Upper Dearne Valley Environmental Trust (UDVET)

Response to Application No. 2024/62/91934/E – Proposed Development of 11 Wood Street, Skelmanthorpe, HD8 9BN.

OBJECTION, COMMENTS AND OBSERVATIONS

Project: Residential Development 11 Wood Street
 Skelmenthorpe HD8 9BN
 Title: Elevations House Type B
 Scale: 1:100 @ A3
 Date: January 2024 Drawg No: LD/244

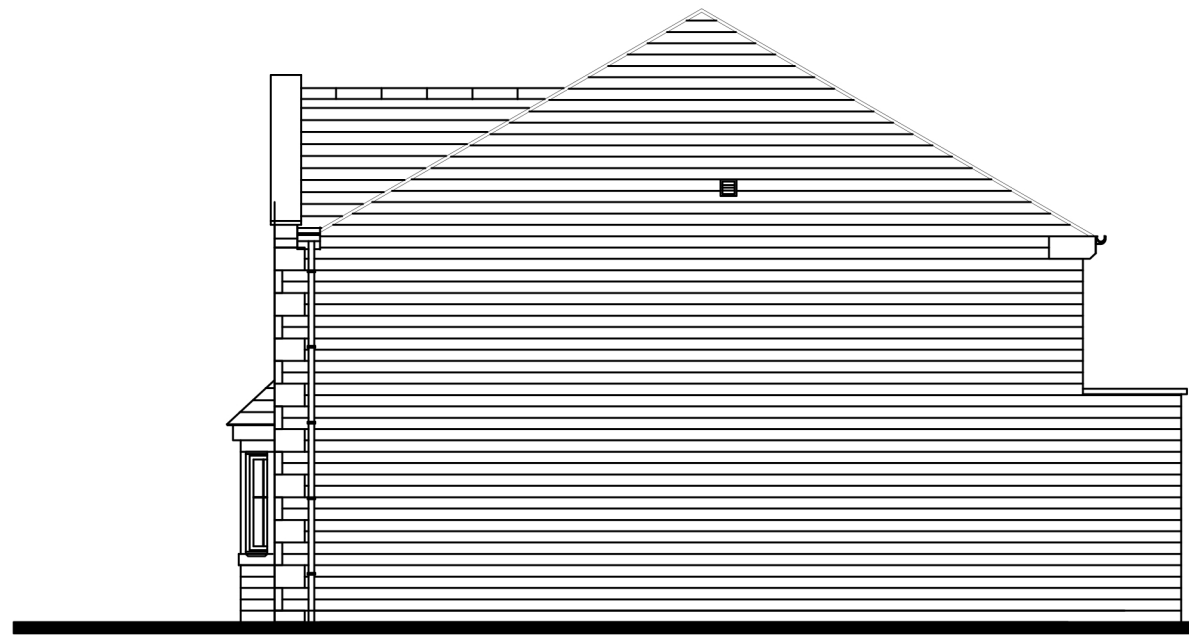
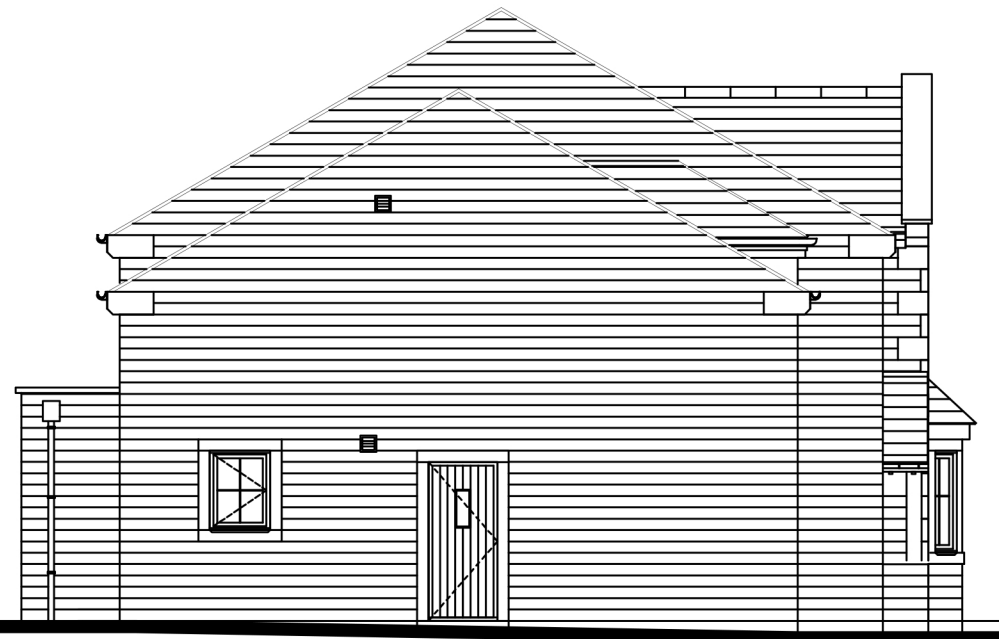
- Similarly, the Type B houses whilst appearing to have a slightly larger garage space have a very restricted parking apron in the front of the properties and turning areas onto the driveway. Although a Tracking Diagram has been provided, it does not

show that turning is possible if another vehicle (likely to be an SUV) is parked on the apron.

APPENDIX 5
TREE IMPACT PLAN

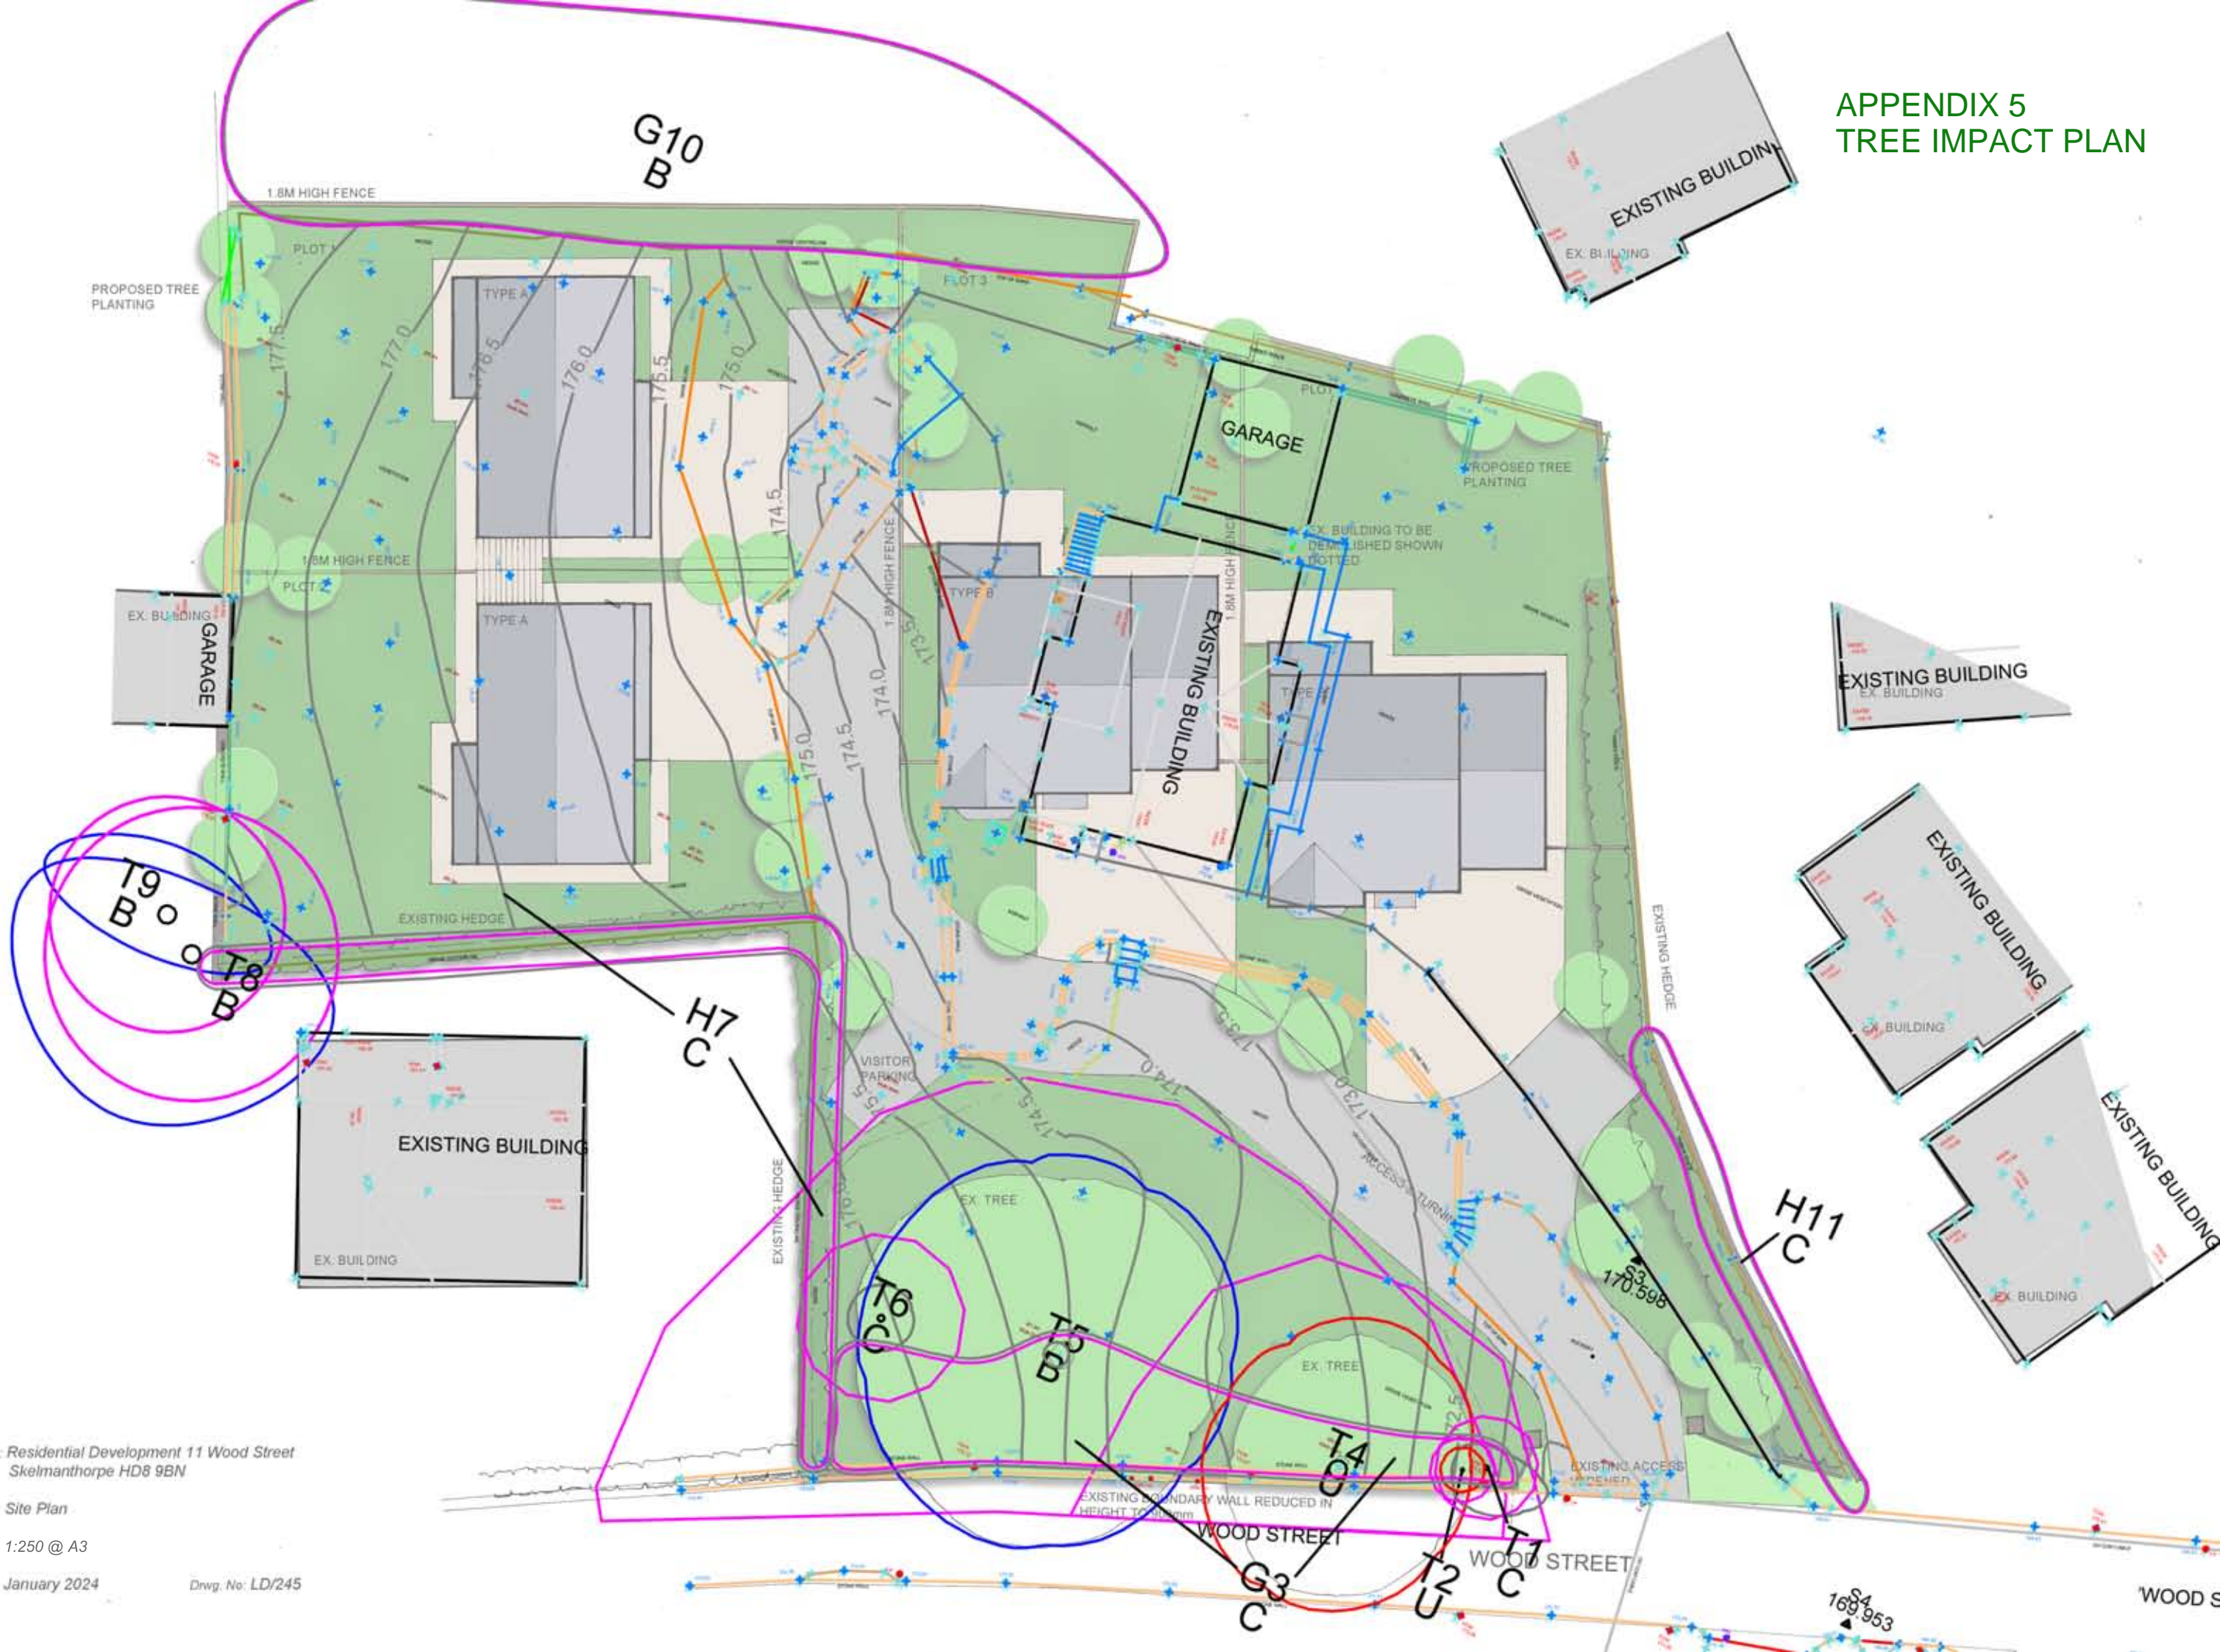
- We have the **STRONGEST POSSIBLE OBJECTION** to the proposed reduction of the existing boundary retaining wall running alongside Wood Street to 900mm. The wall is currently over twice this height and serves to support the cut through of Wood Street through a naturally occurring mound and bedrock.

Reducing its height is very likely to destabilise the existing two TPOs which are a feature of Wood Street and bring great amenity value. This reduction in height is simply not necessary.

- Finally, we have some concern that the recutting of the driveway may impinge on the required root protection zones of the TPOs, especially the Sycamore closest to the driveway. We trust the Tree Officer (as well as other Statutory Consultees) will be gaining access to the site to take appropriate measurements and enforce suitable protections in addition to the wall issue mentioned earlier.

For example, the Consultant appears to be under the impression a new native species hedge is to be planted along the western boundary of the site. This is NOT shown/indicated on the submitted Site Plan.

- It fails to point out, as does the Site Plan, the position of the driveways to Field House and The Barn House opposite the entrance to 11 Wood Street. The Tracking Diagram also fails to show these entrances and the position of the drystone walls.
